RE: AP-84-17 (2A-84-119)
Location: Lots 239 and 240, Block 22
Arrijo Brothers Addition, 715 Lomas Boulevard, N.W. (J-14) 43

REF DR. PETERSON'S OFFICE ADDITION (J14-D43) BLOCK 17 ARMIJO
ADDITION.

Based on the information provided on your June 14, 1984 submittal of the above referenced site, listed below, you will find certain items that will need to be addressed before final approval is granted.

C-1

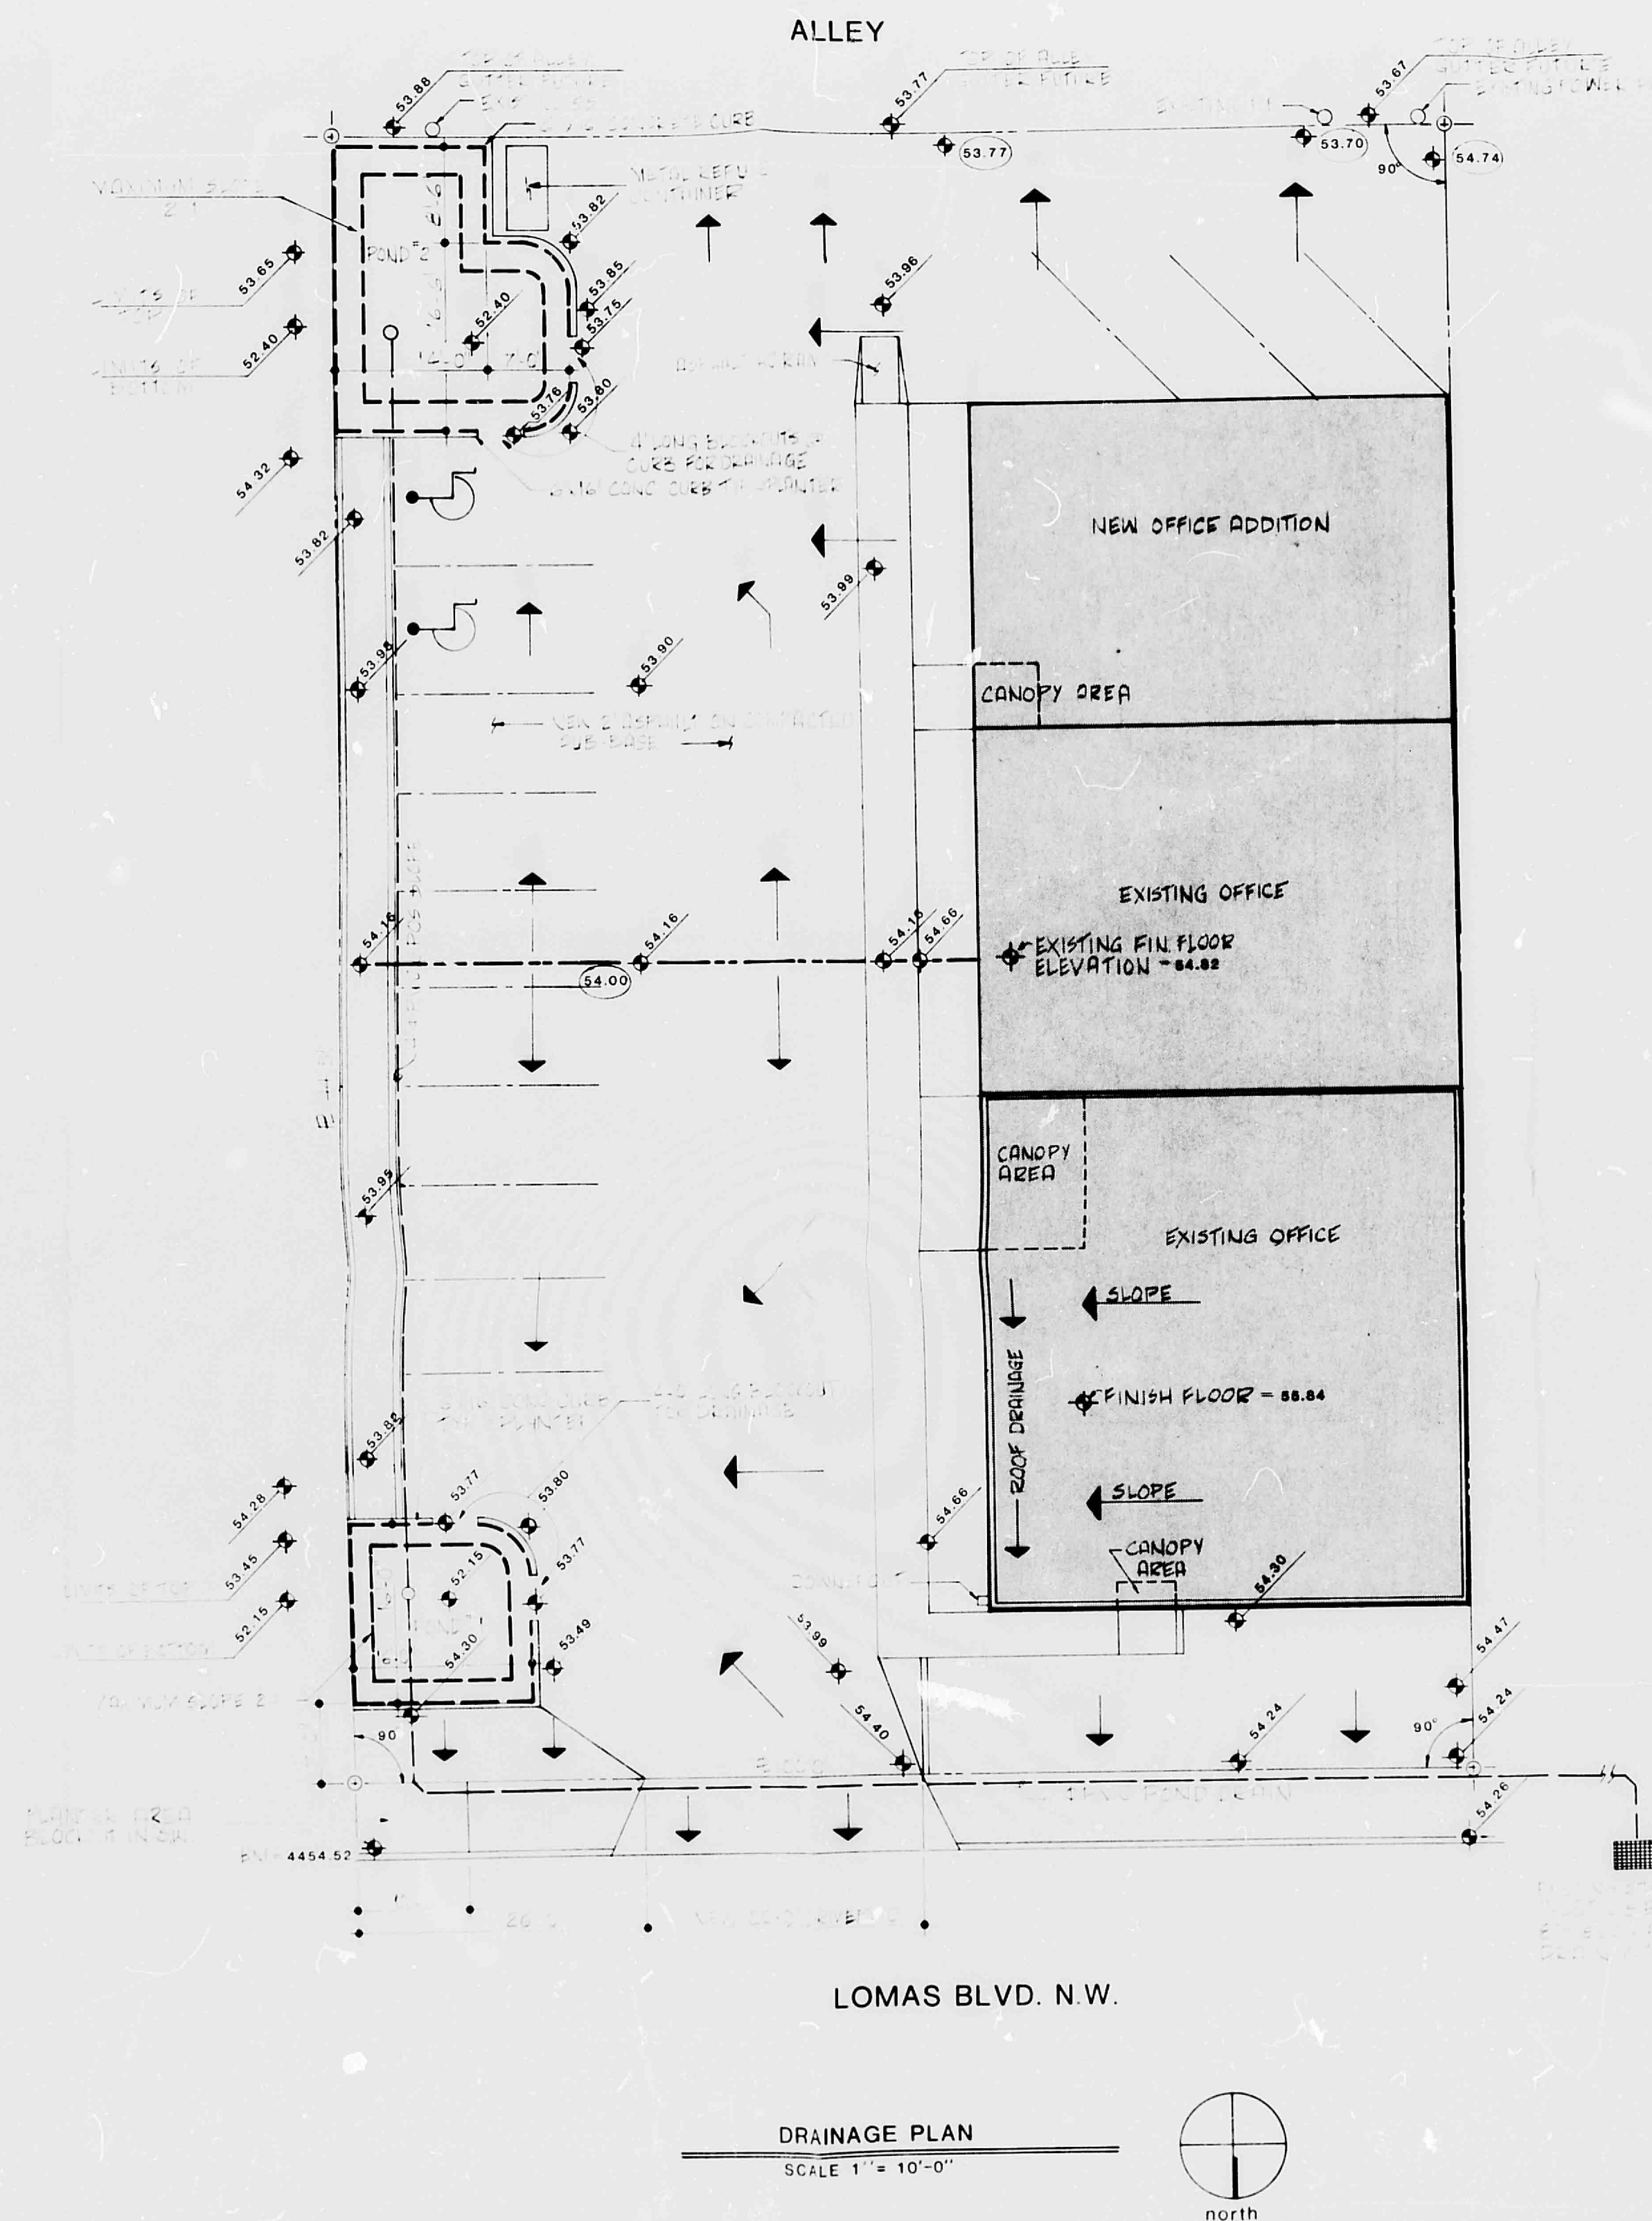
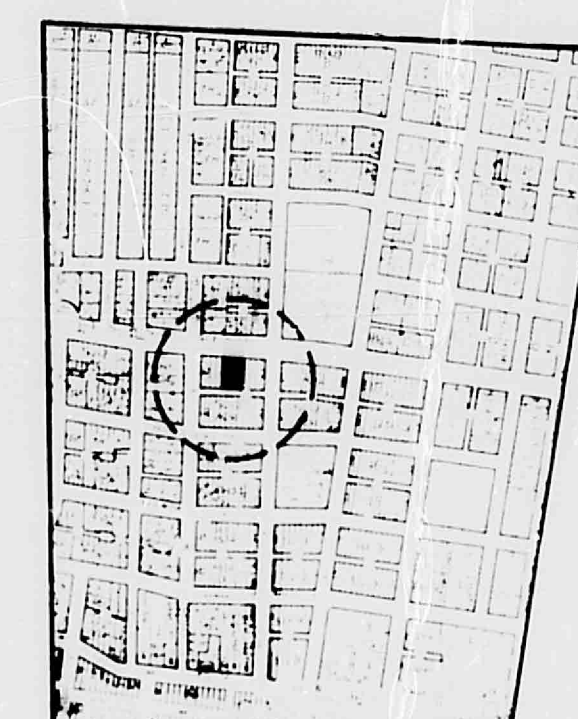
1. We will need an updated plan reflecting the proposed finish floor to mean sea level.
2. Also we will need the updated plan to reflect your professional stamp, signed and dated.
3. A notation will need to be inserted on the plan addressing the fact that the original ponding areas were eliminated and that they will be reconstructed per plan.
4. We will need verification from City Engineer's Office inspection section that they have inspected the tie in to the existing catch basin on Lomas.

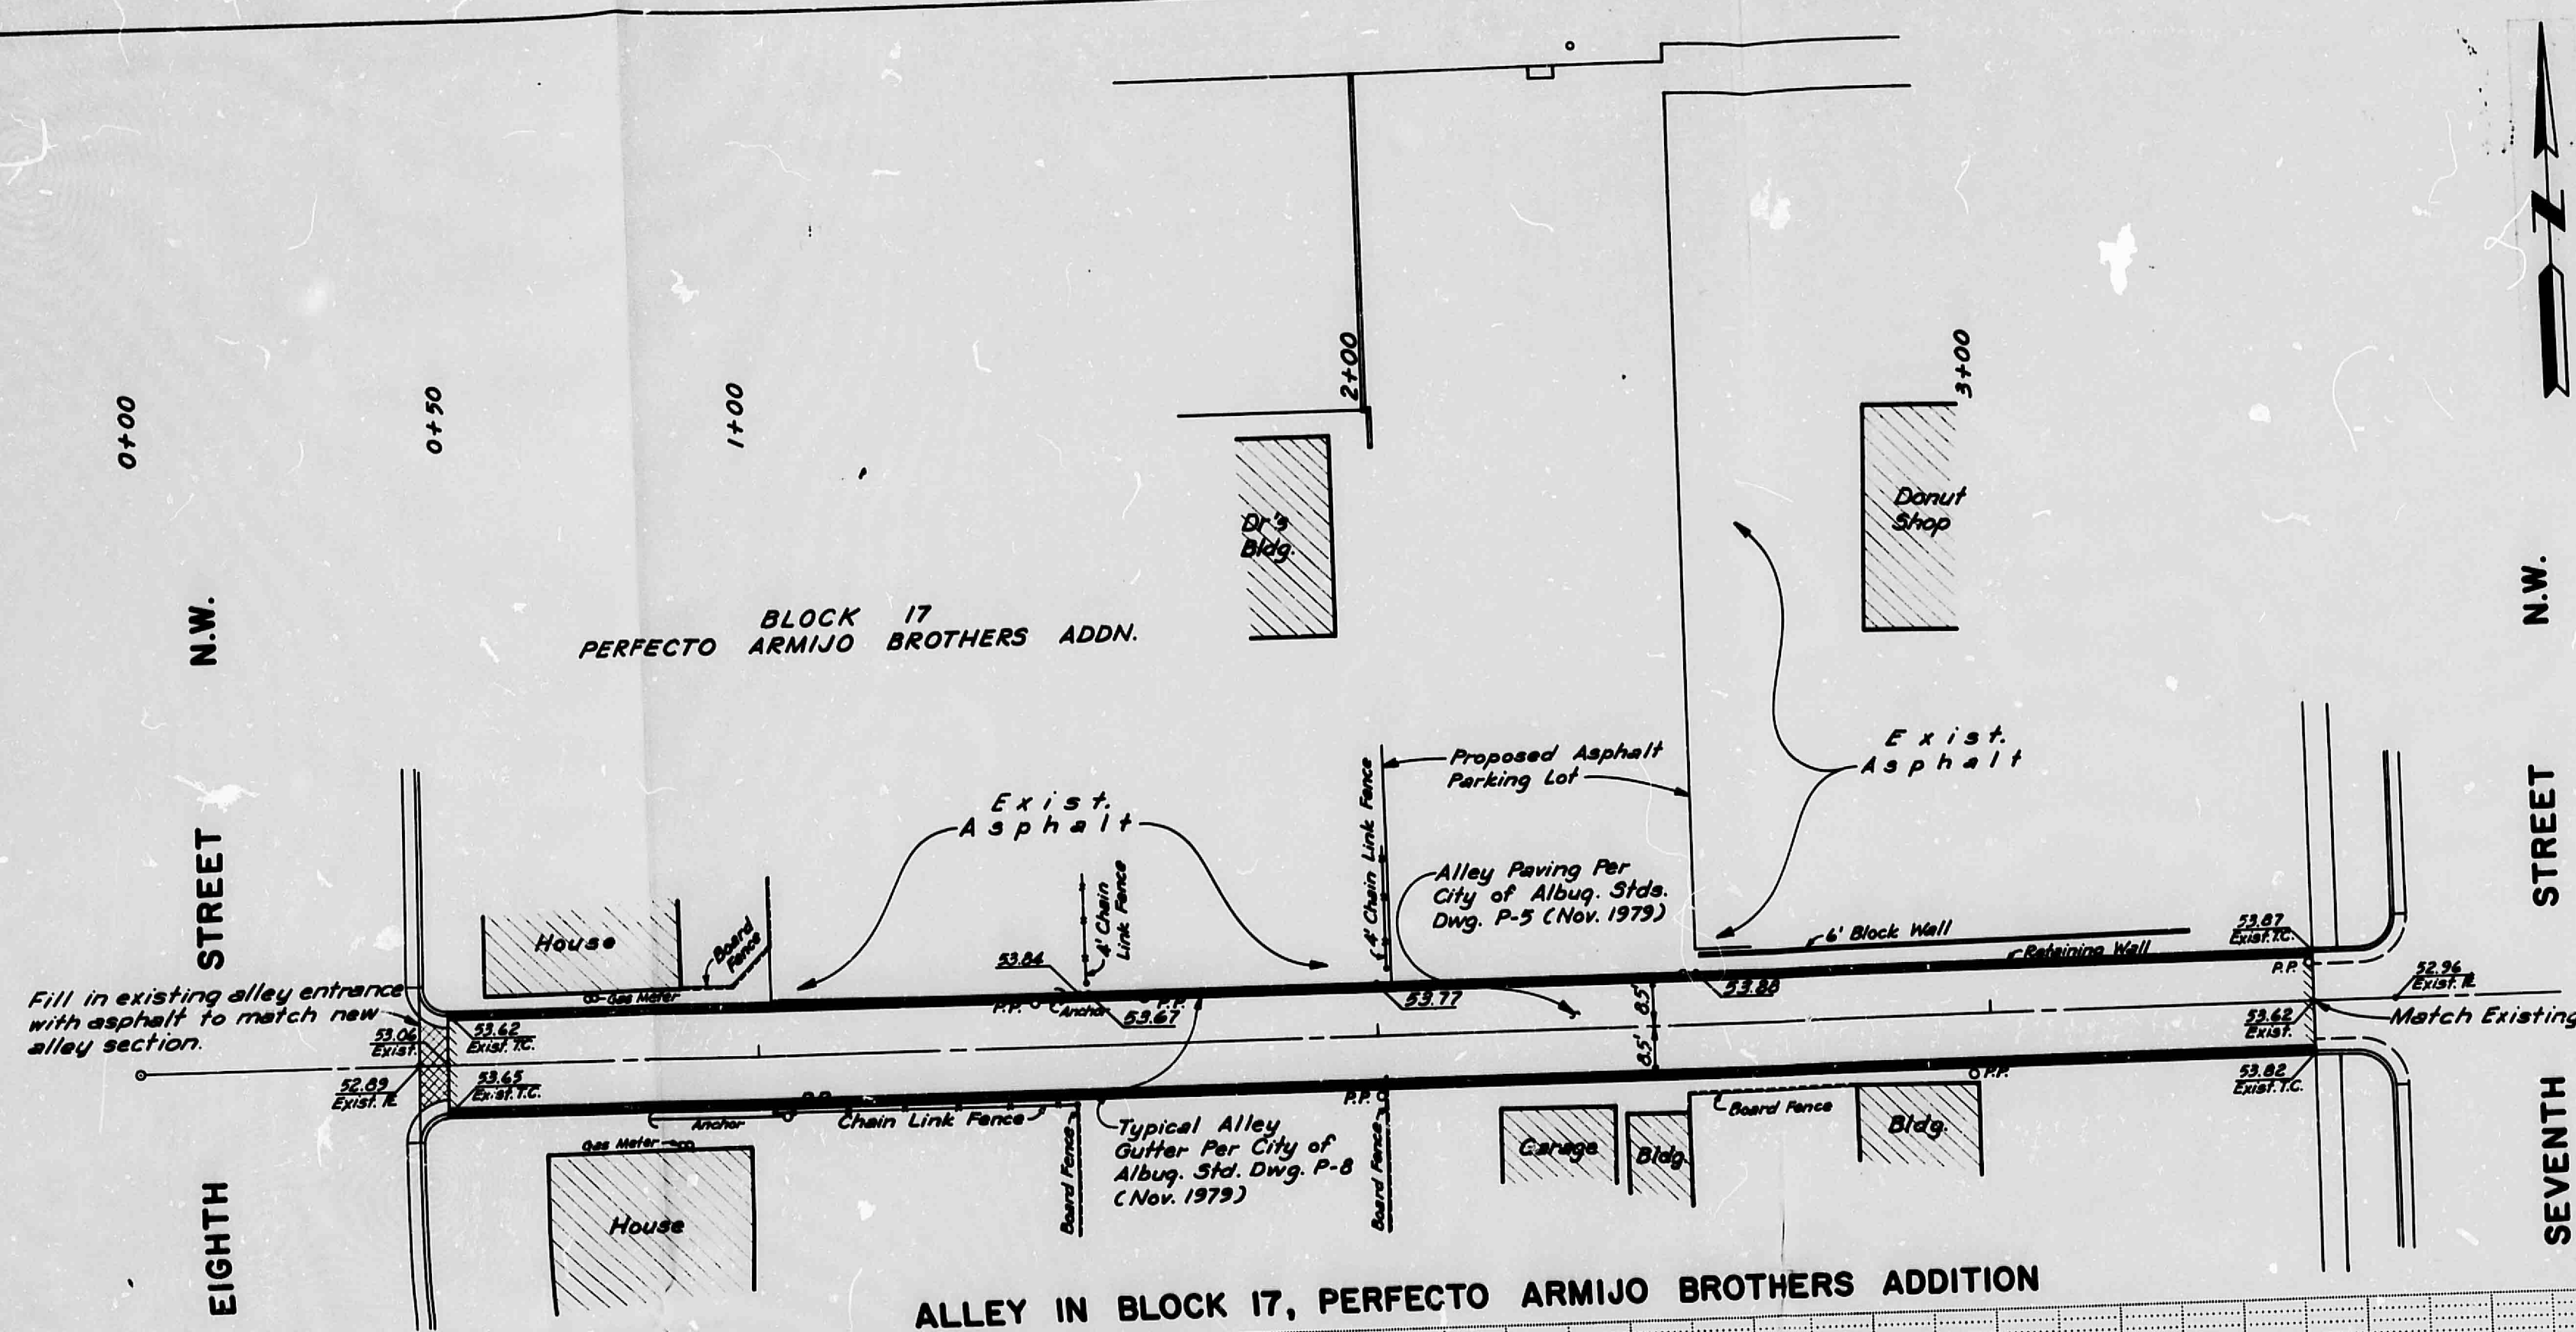
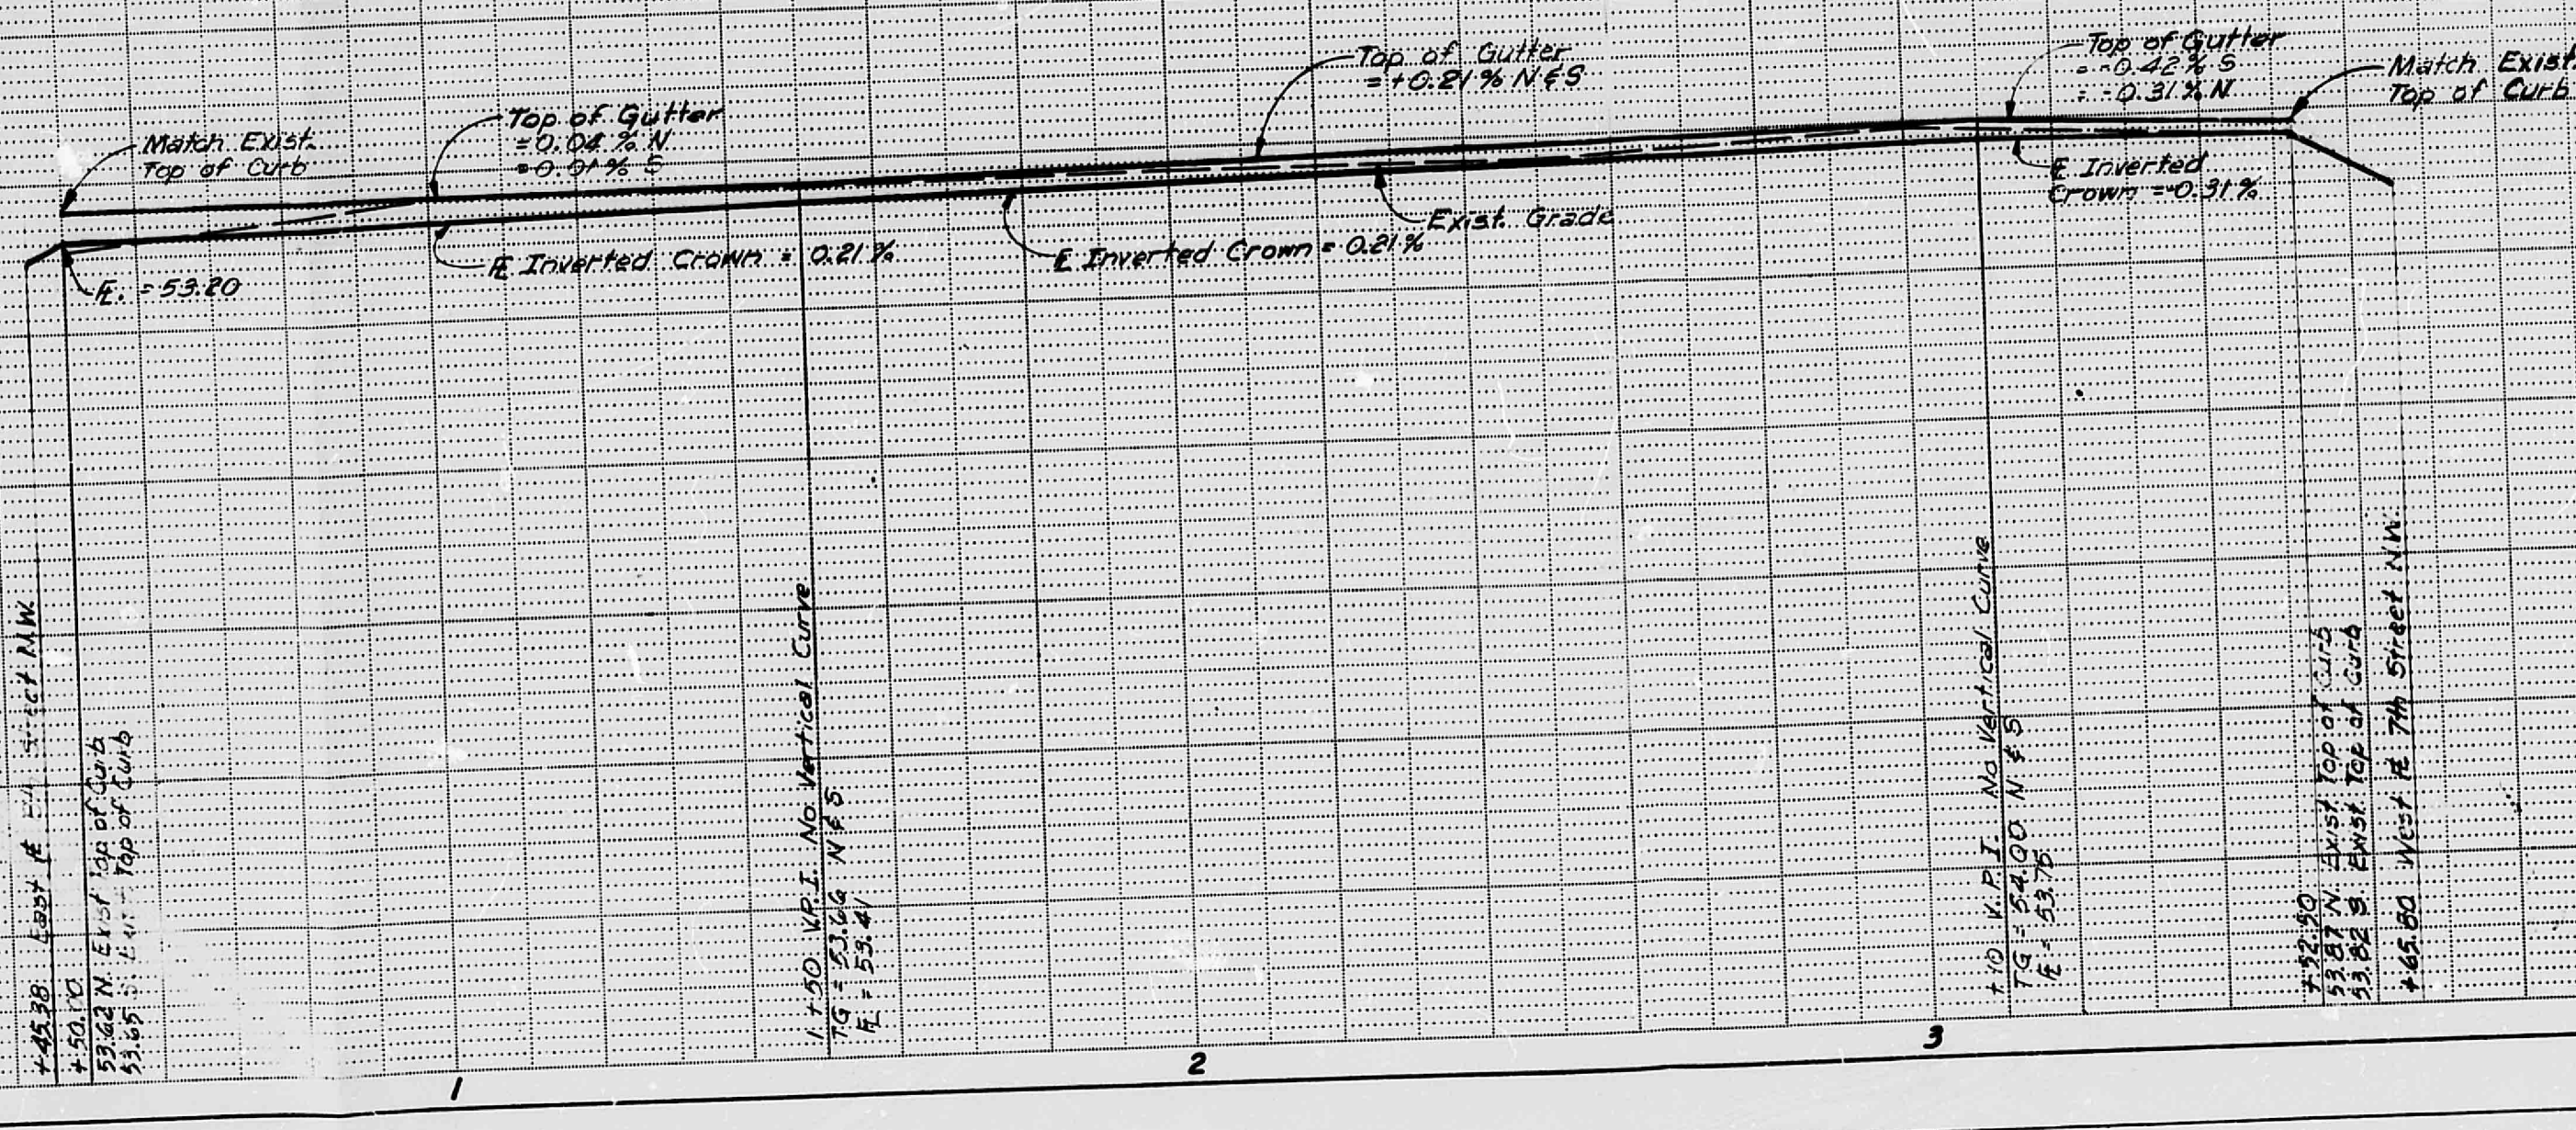
Regarding the paving of the alley we ask that the grade of the pavement be such that it will not interfere with the drainage of our property which is lots 241 and 242 of the same block. The drainage of our property is to that alley and it has to remain the same. Therefore, the grade of the pavement should be such that the drainage is not blocked.
